From: David Kuchanny [REDACTED]
Sent: 23 July 2015 12:52
To: Simon Davis
Cc: Mark Webb; Mail
Subject: re: Planning Consultation on AL/66/15/DOC

Subject: **Planning Consultation on AL/66/15/DOC**

## New garage room windows at scale 10:1

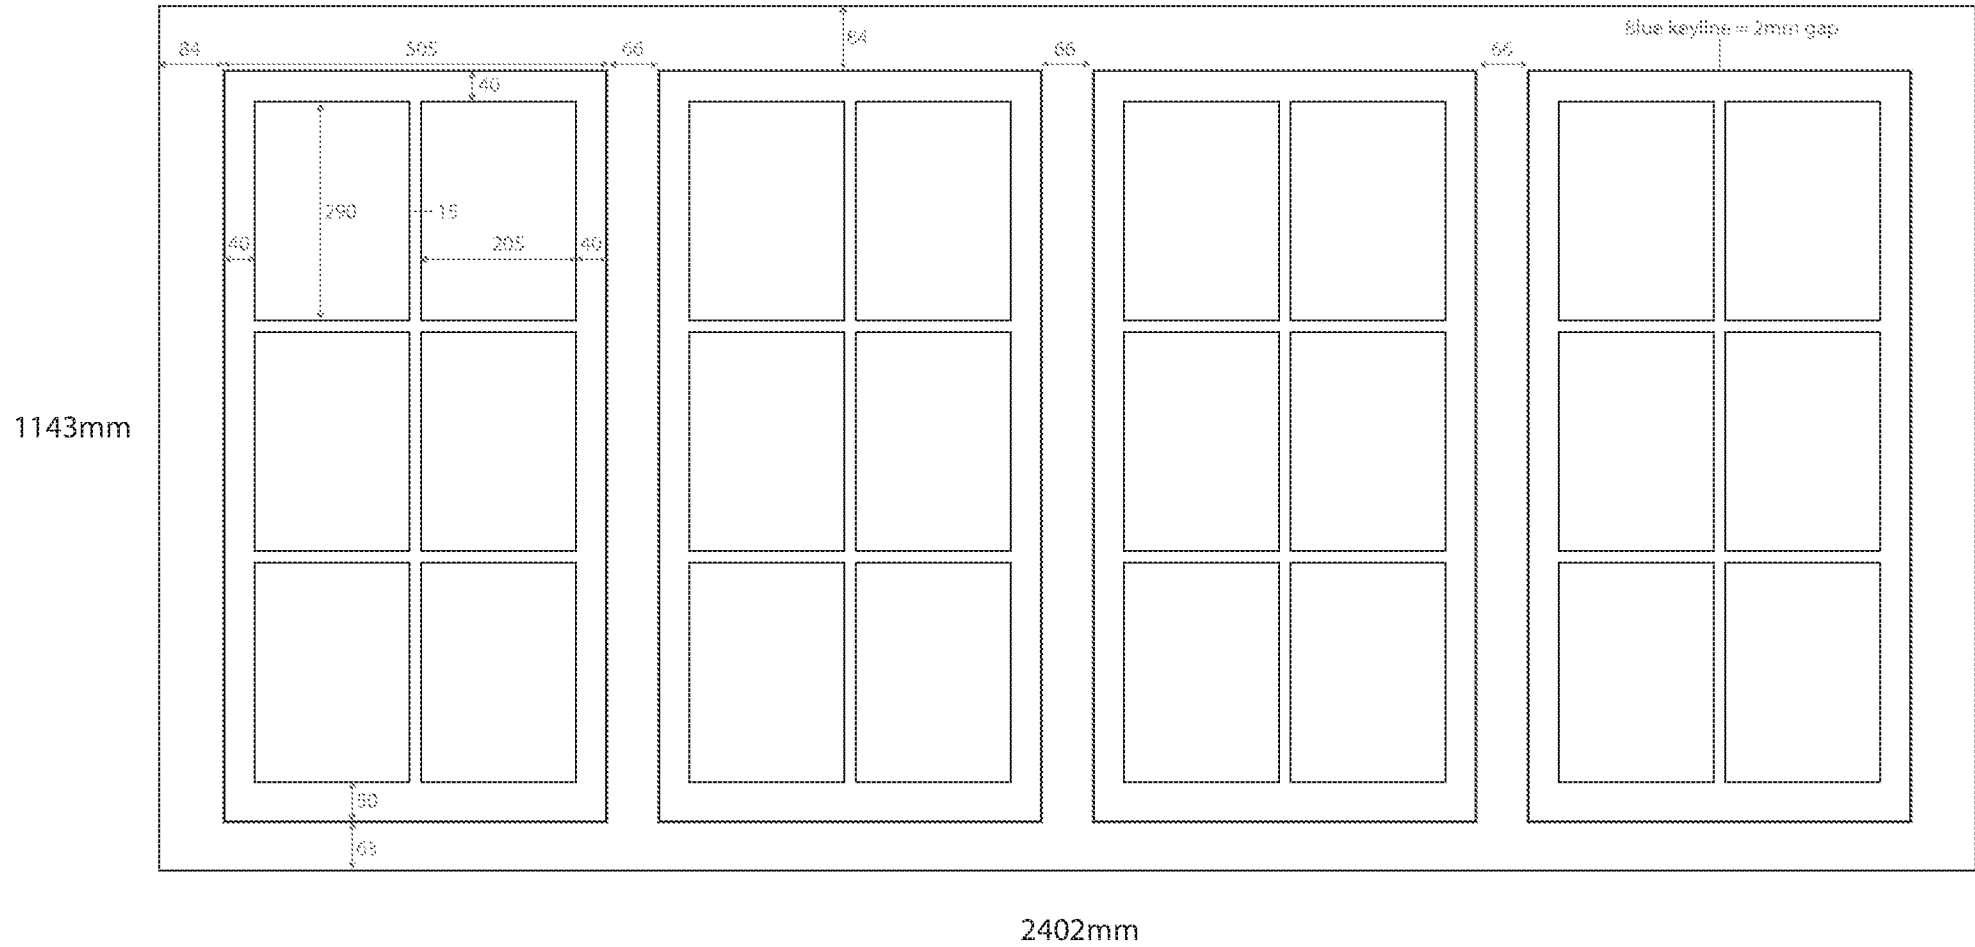
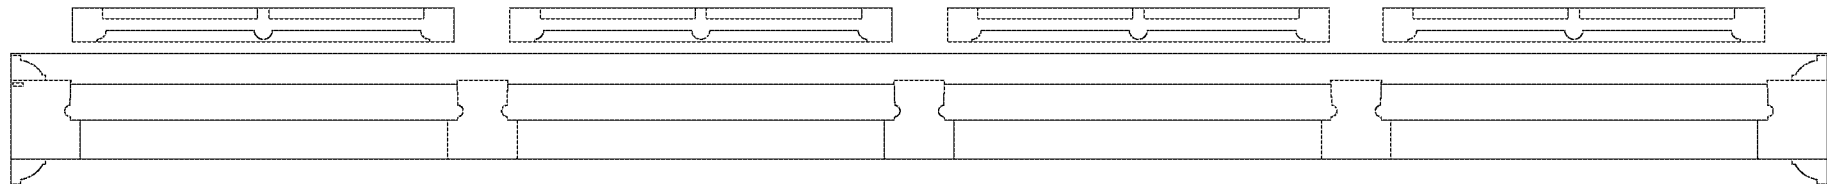
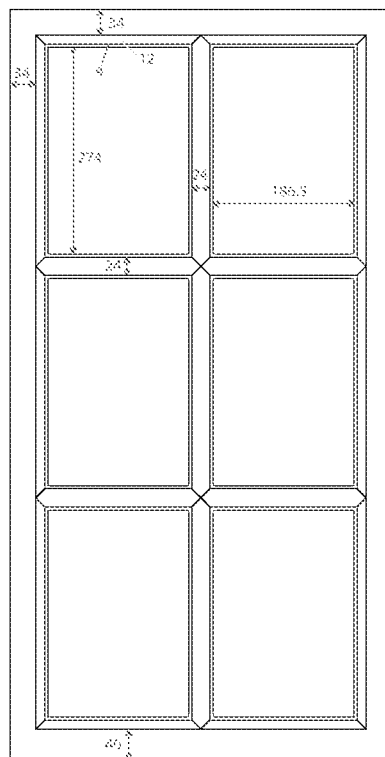
Condition 3 - we will go for a slim DG unit then (I believe 14 or 16mm is standardly available now
